Your ref:
Our ref: 21/01897/F
Please ask for: Mrs Joanne Rahman
Direct dial: 01553 616233
Direct fax: 01553 616652
E-mail: borough.planning@west-norfolk.gov.uk

Details: **Proposed glass green house and agricultural store for new cut flower business at The Old Barn Greens Lane Tilney All Saints King's Lynn Norfolk**

I have received a planning application as detailed above but cannot process it until I receive some more information:

Drawing Title:
EXISTING SITE & LOCATION PLAN

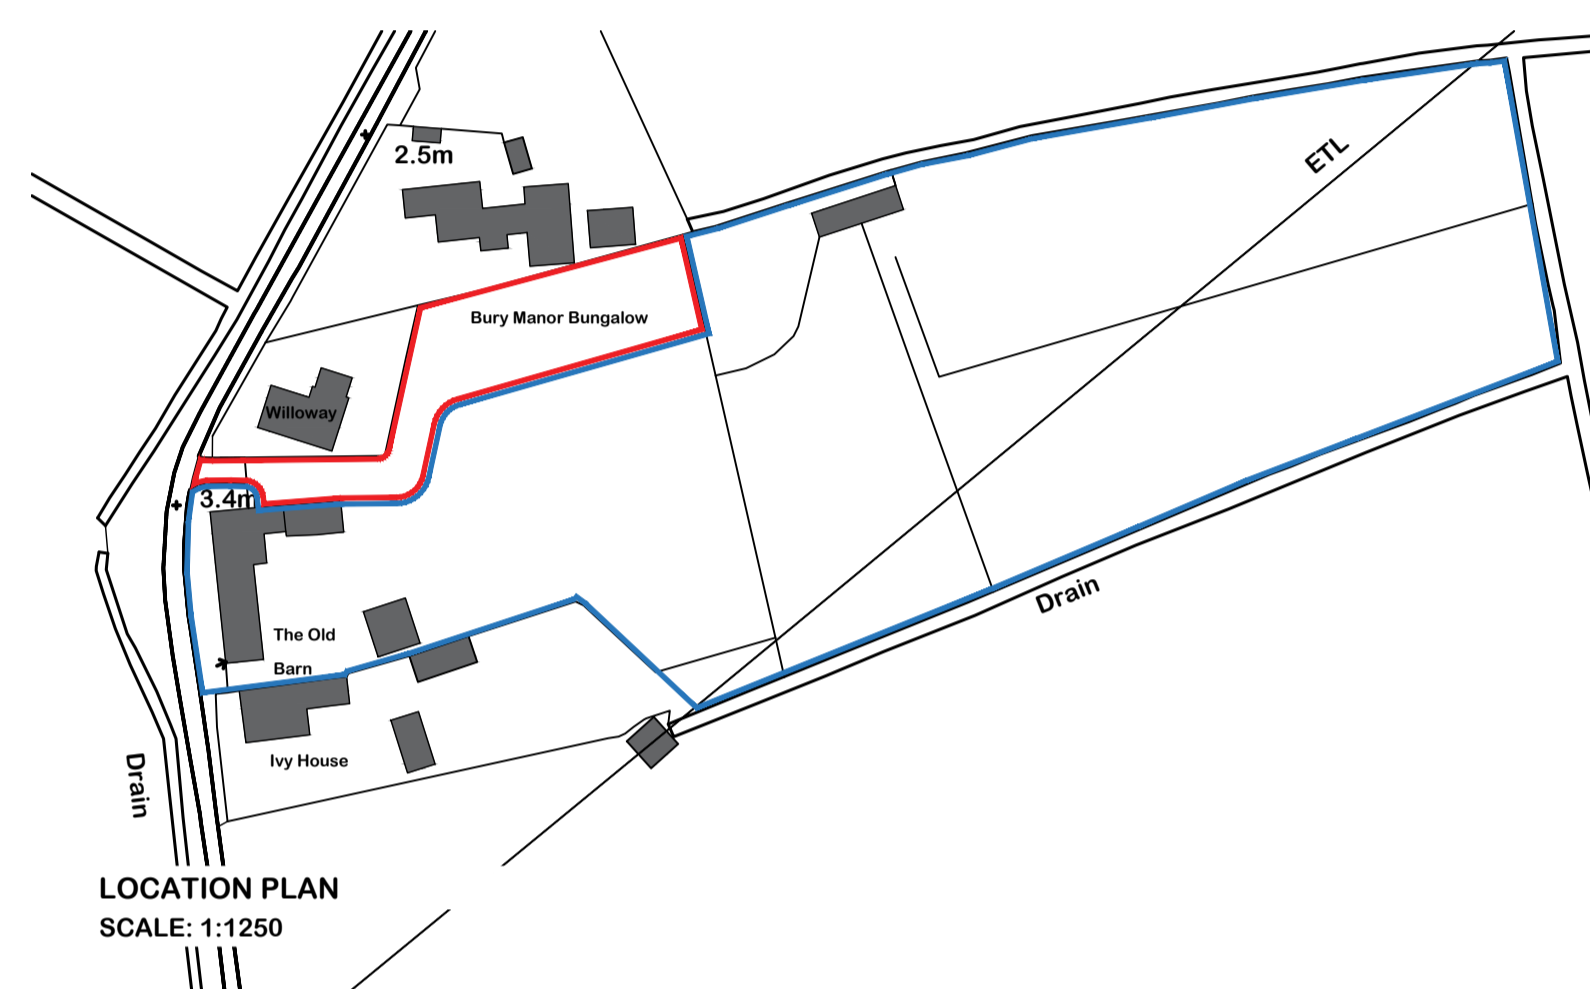
1. A Flood Risk Assessment is required to be submitted with this application, as the site lies within an area at risk of flooding.
2. Please amend the proposed floor plan to show the roof lights reflected on the floor.
3. Please provide four drawings to a recognisable scale, showing existing and proposed site levels. If the site levels are to remain unchanged, please provide the drawings annotated as existing and proposed.
4. As the property lies within an area at risk to flooding, please complete the simplified Matrix and return it. The Matrix can be found at https://www.west-norfolk.gov.uk/info/20173/information_for_planning_agents/231/flood_risk_information
